CITY OF ALBUQUERQUE

June 22, 2021

**Re: Lot 18 Block 38 Volcano Cliffs Subd. SAD 228
6636 Sujeto Rd NW
Grading & Drainage Plan
Engineer's Stamp dated: 4-28-19 (D10D003K15)
Revised for pool Date: 4-28-19**

Lots 15, Block 5, Volcano Cliffs Subdivision, Unit 18
6636 Sujeto Road, NW, POOL/SPA ADDITION
GRADING PLAN

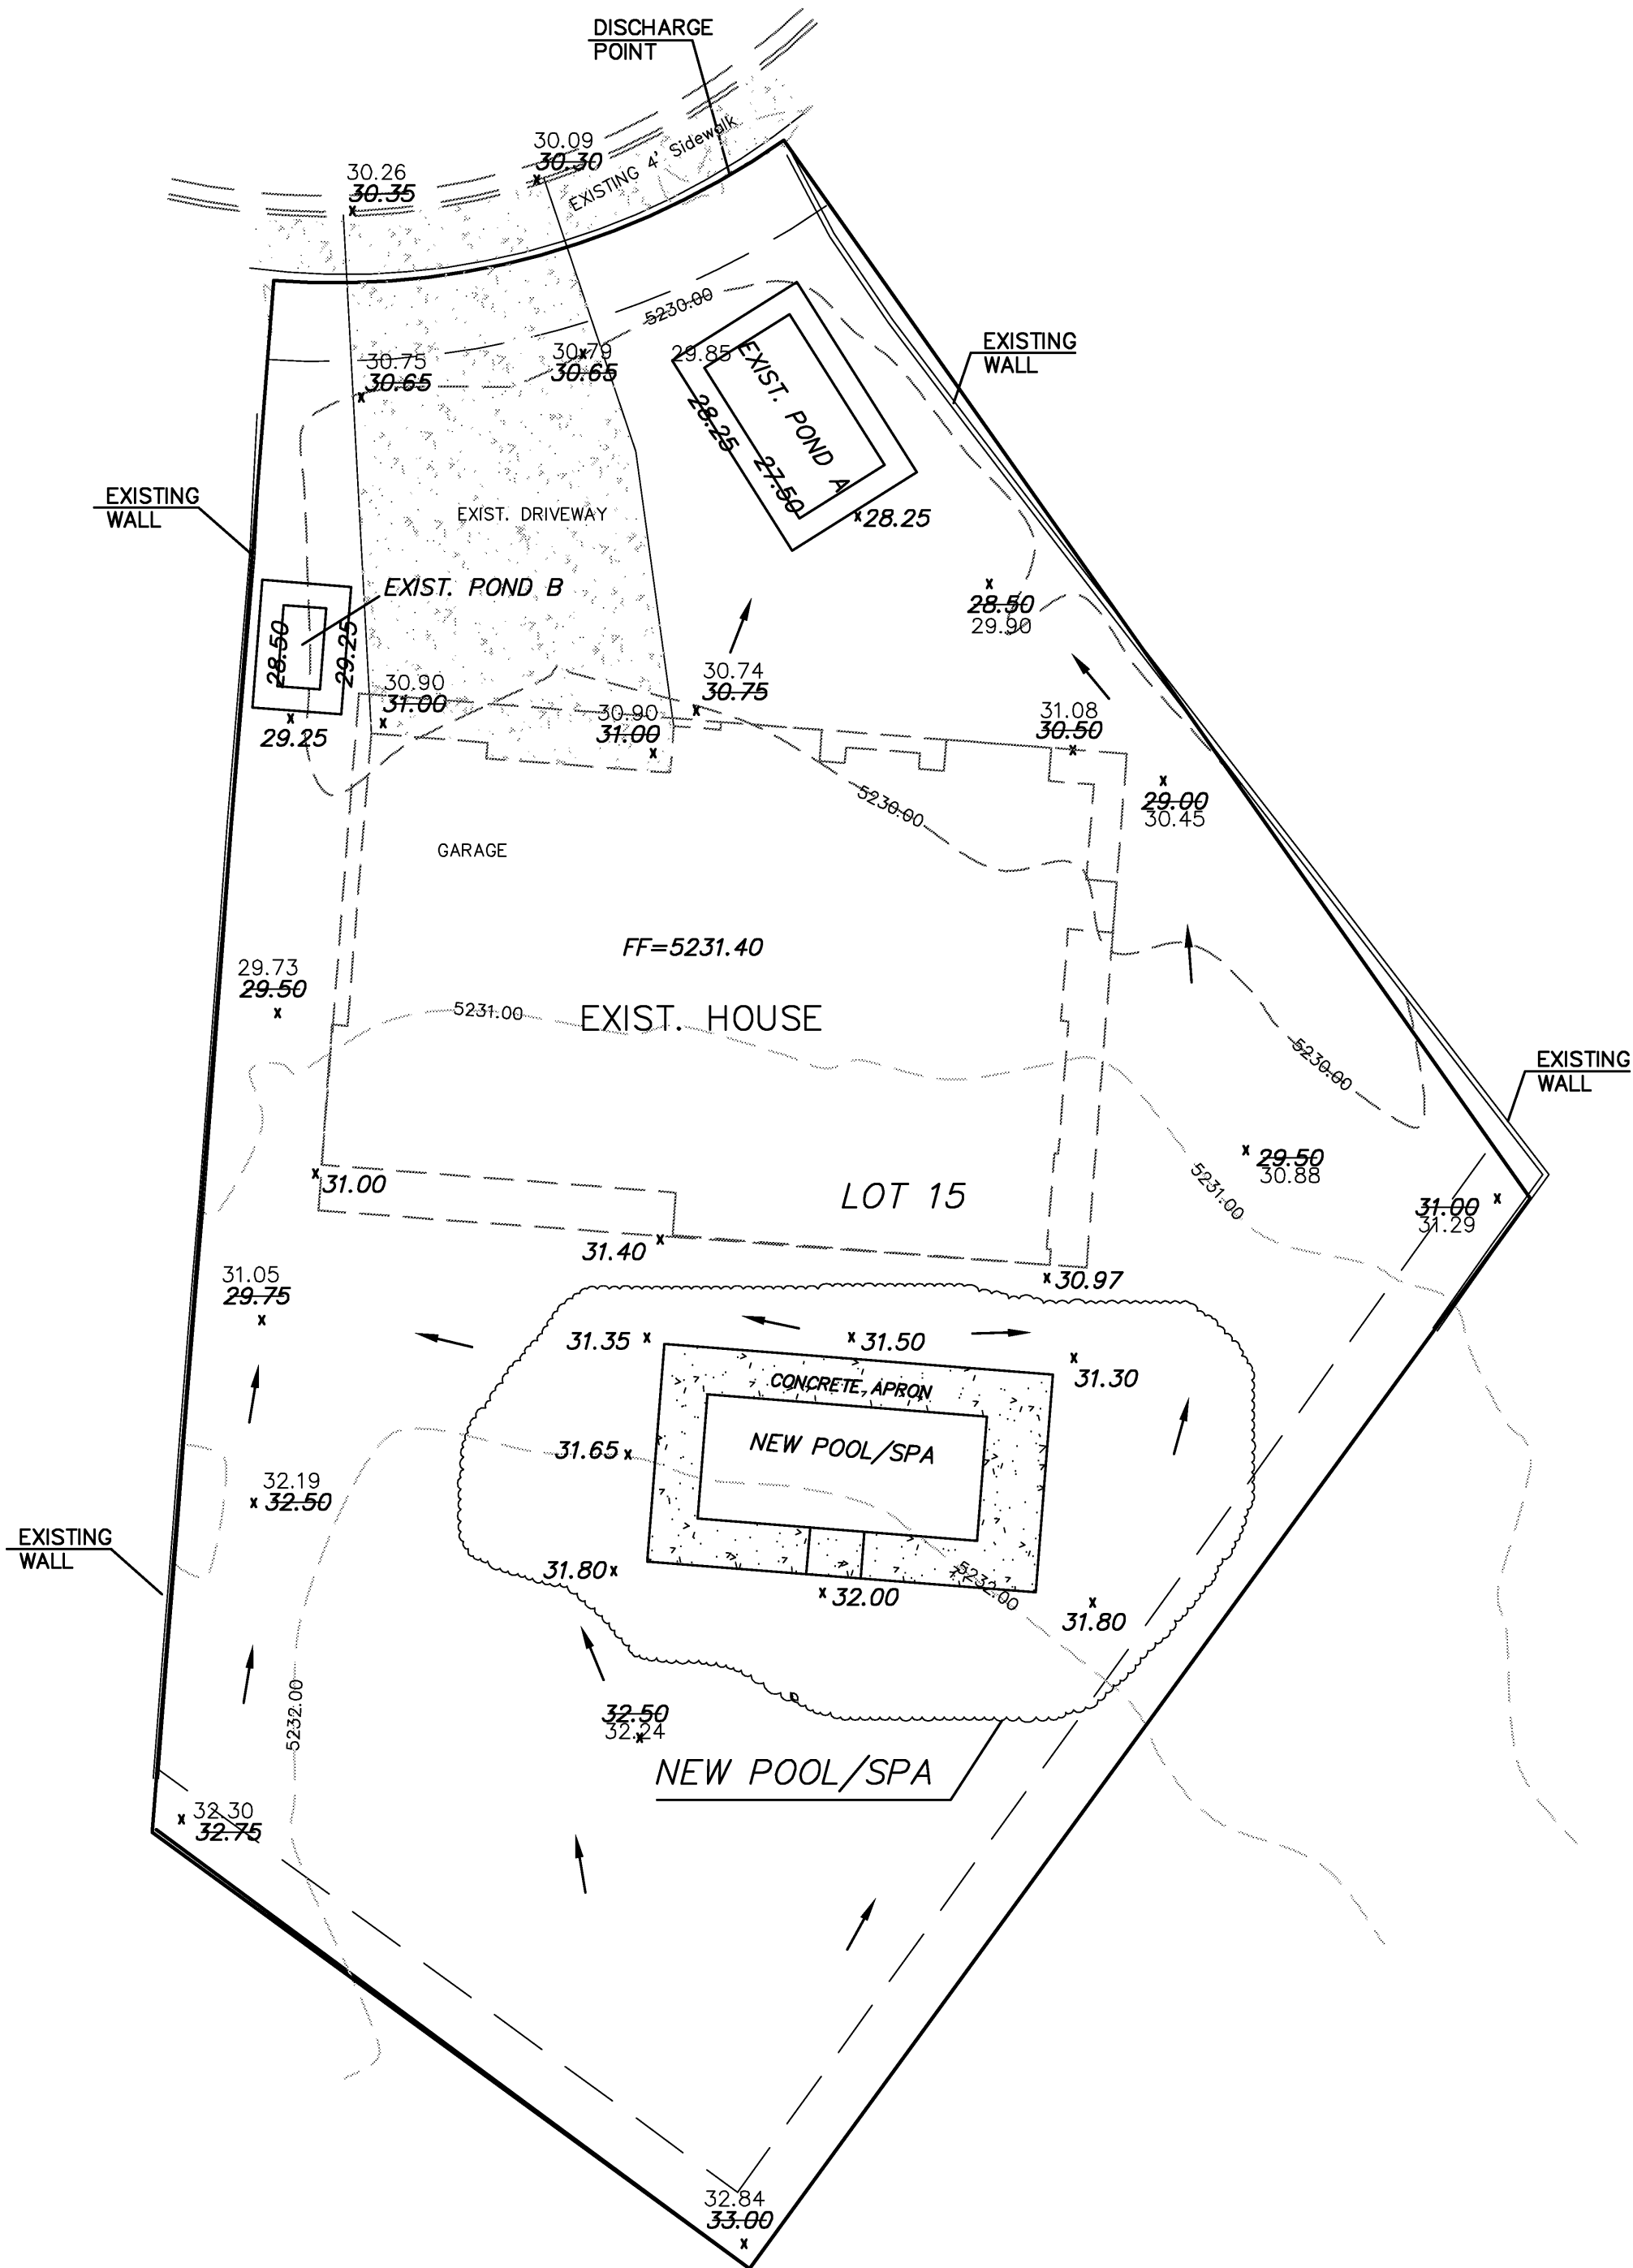
- The approval date is the same as the original approved date. Provide a new approval date with a note stating the changes.
- Provide the new land treatment amounts in red along with the original land treatments.
